**re: Geotechnical Design Summary Details**  
**Proposed Residential Development**  
**5331 Fernbank Road – Ottawa, Ontario**

**file:** PG5683-MEMO.02 Revision 4

Further to your request and authorization, Paterson Group (Paterson) prepared the current memorandum to provide a grading, servicing and landscape review for the proposed residential development. The following memorandum should be read in conjunction with the Geotechnical Investigation Report (Paterson Report PG5683-1 Revision 1, dated November 13, 2025).

CITY OF OTTAWA 5331 FERNBANK ROAD IRON VALLEY 2		PROJECT No. 121011-00	
DRAWING NAME GENERAL PLAN OF SERVICES		REV # 6	
		DRAWING No. 121011-GP2

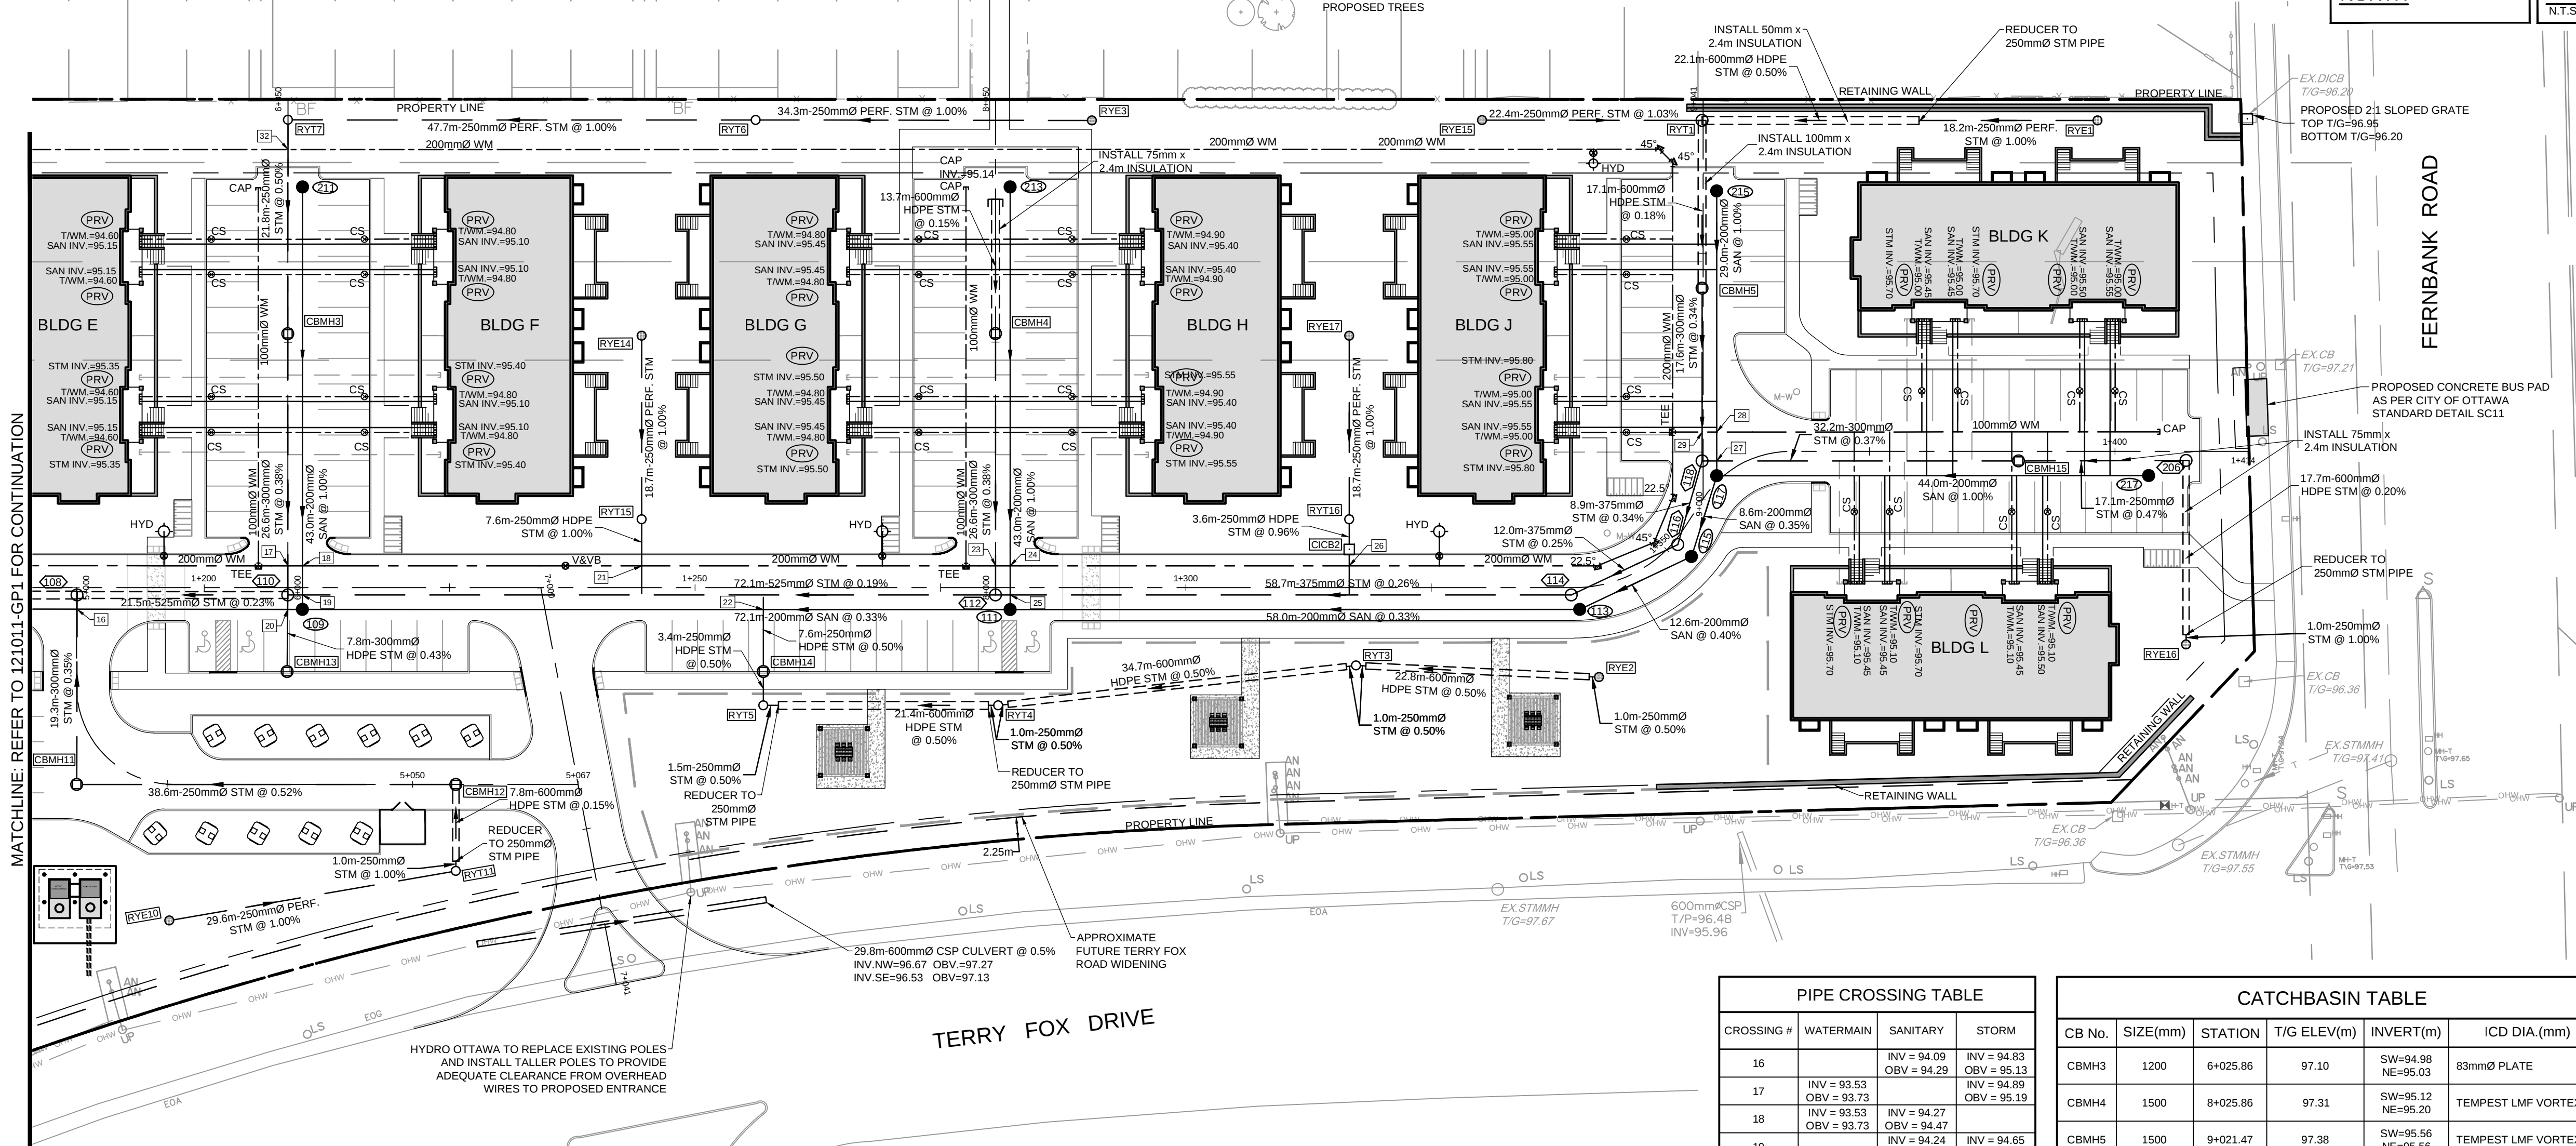
From our review of the above-noted site servicing plan, a number of servicing pipe sections are not provided with sufficient soil cover of 2.1 m for adequate frost protection (measured from the proposed ground surface to the pipe obvert). Reference should be made to the marked-up servicing plans which show the areas with insufficient soil cover, attached to the current report.

It should be noted that the elevations of the watermain profiles are not available at the current time. Based on the pipe crossing obvert elevations, it is anticipated that all watermains will be provided with sufficient soil cover for frost protection (without insulation). Paterson should review the watermain elevations for verification, once available.

For services with less than 2.1 m soil cover, a combination of soil cover and rigid insulation should be used, as detailed in Table 1 below.

Table 1 – Rigid Insulation Recommendations for Pipes with Reduced Soil Cover			
Thermal Condition	Soil Cover Provided (mm)	Insulation Dimensions	
		Thickness (mm)	Extension (mm)
Unheated	1800-2000	25	Extend 600 mm horizontally beyond edge of the pipe
	1500-1800	50	Extend 900 mm horizontally beyond edge of the pipe
	1200-1500	75	Extend 1200 mm horizontally beyond edge of the pipe

Alternatively, instead of extending the rigid insulation 600 to 1200 mm beyond the edge of the pipe, the rigid insulation can be “boxed” around the pipe by transitioning from horizontal to vertical placement of the rigid insulation and extending to the invert pipe elevation, effectively forming a box of rigid insulation around the pipe. In this case, the rigid insulation should still be extended far enough to provide adequate spring-line and cover backfill material around the pipe.

1 LANDSCAPE PLAN  
 SCALE 1:300

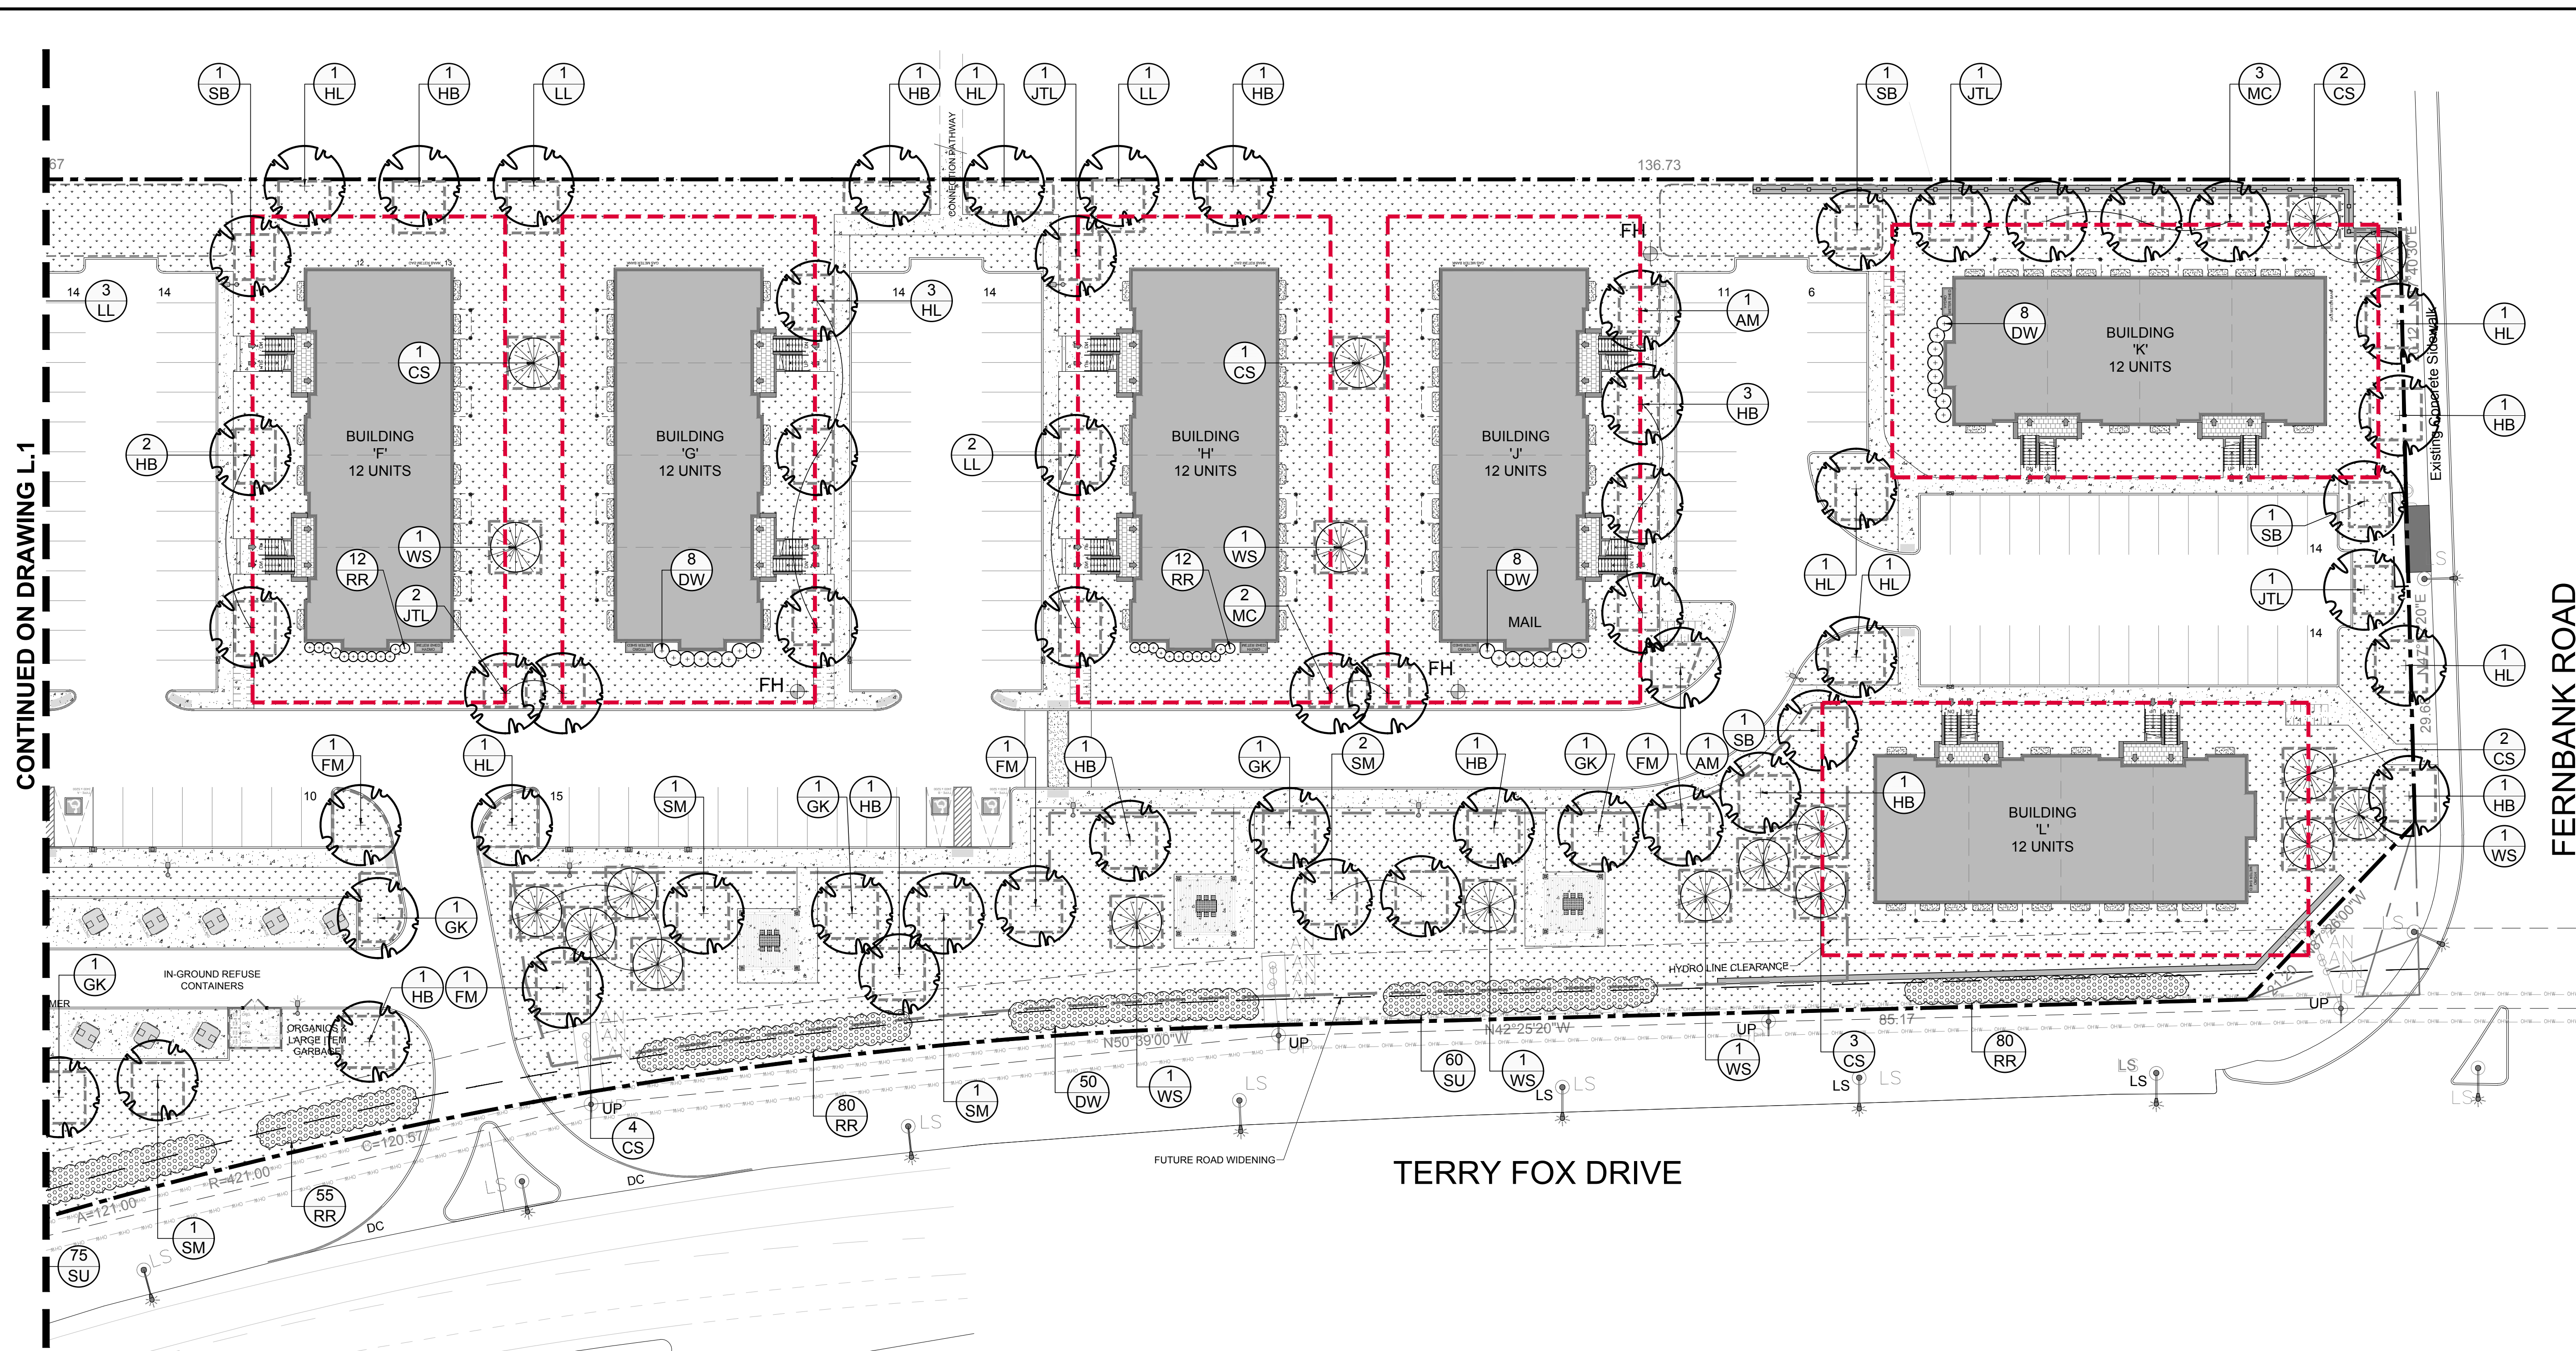
Based on the above-noted drawing, a minimum setback of 4.5 m from the nearest building foundation is provided for the majority of the proposed trees at the subject site. However, a small number of trees are not provided with the required 4.5 m setback. Reference should be made to the marked-up landscaping plans which show the trees with an insufficient setback, attached to the current memorandum.

Per discussion with JBLA, the proposed trees will consist of Japanese Lilac trees with a shallow, non-aggressive root system. Furthermore, it is understood that the remainder of the conditions noted in Subsection 3.1 of the current report will be incorporated into the design of the proposed development.

Accordingly, the proposed landscaping design is acceptable from a geotechnical perspective and is in conformance with Paterson's recommendations provided in the aforementioned geotechnical investigation report.
